From: Holly Duncan
Sent: Thursday, June 28, 2012 10:43 AM
To: Jeff Watson
Subject: RE: BL-12-00014 Juniper Village

From: Jeff Watson
Sent: Wednesday, June 27, 2012 10:51 AM
To: Christina Wollman; Brenda Larsen; Jan Ollivier; Holly Duncan
Subject: BL-12-00014 Juniper Village

[BL-12-00014 Juniper Village](#)

Proposed Configuration

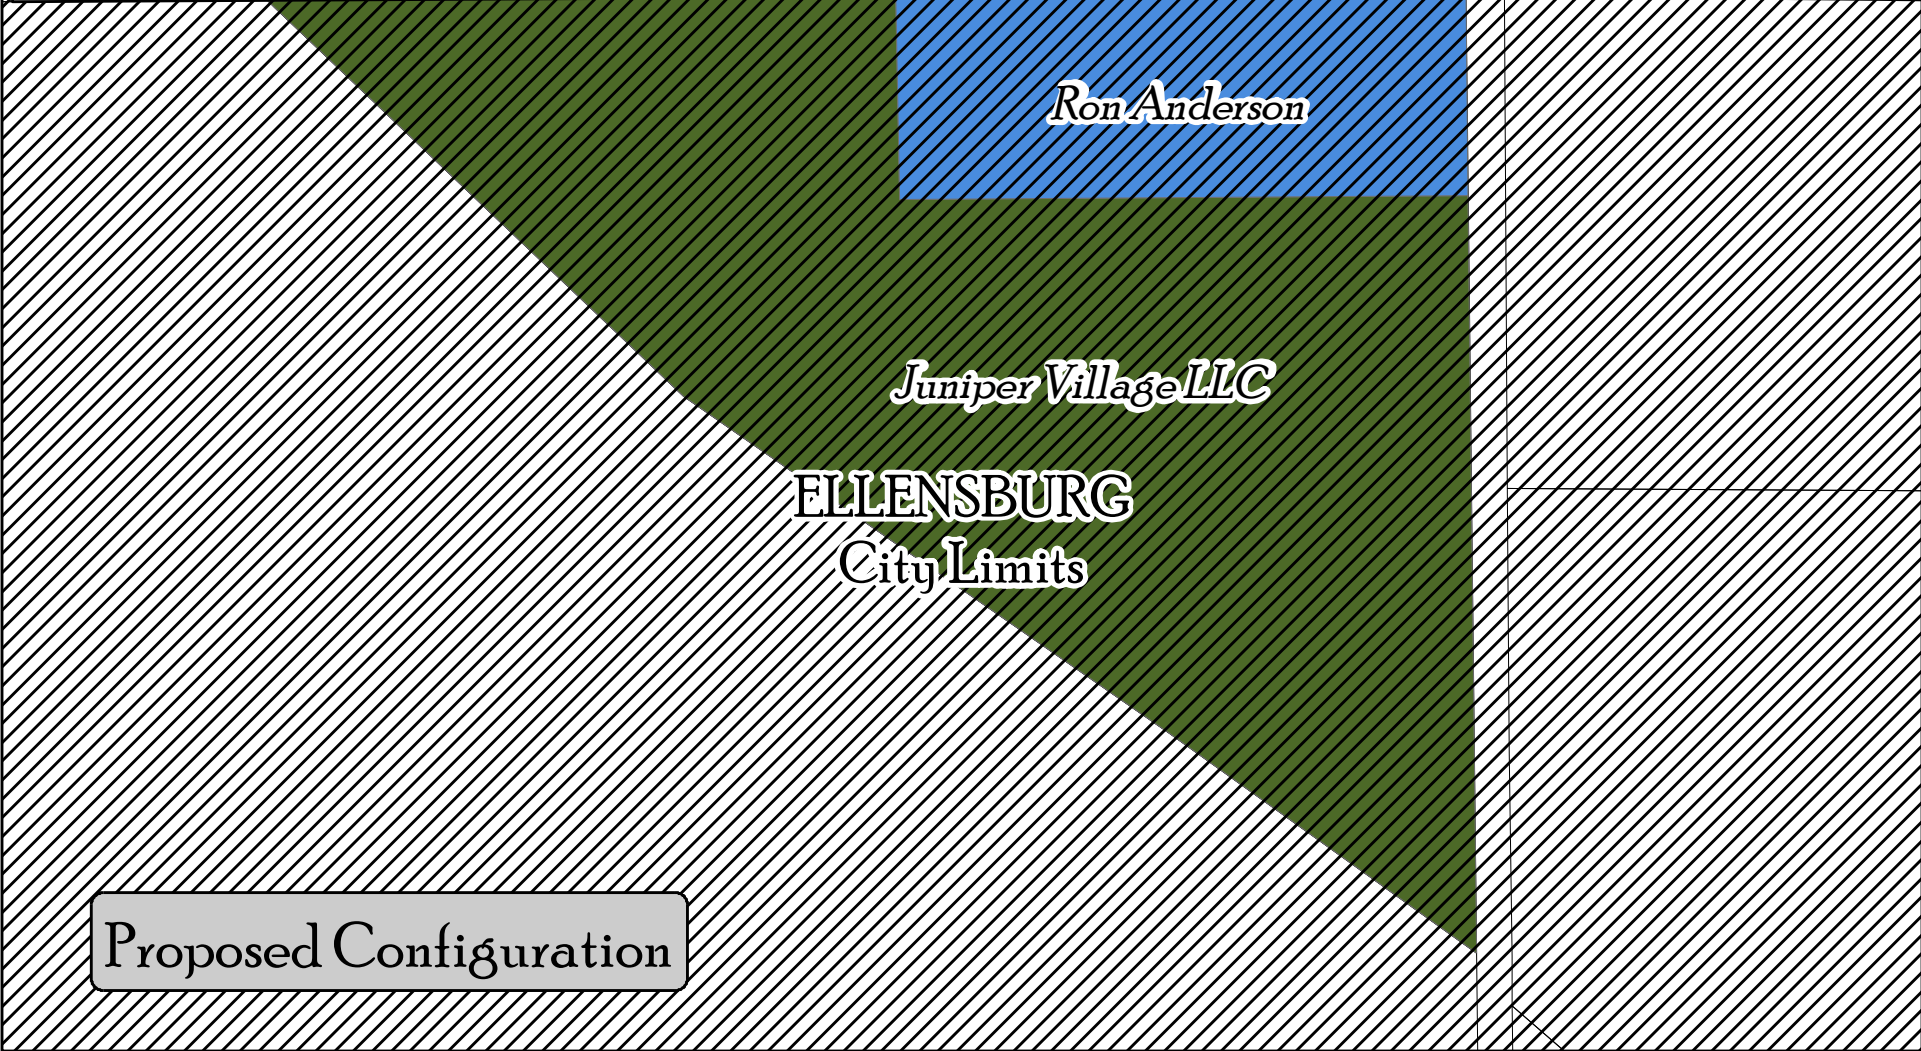
The proposed lot lines don't appear from this information, to create any problems with existing wells or drainfields.
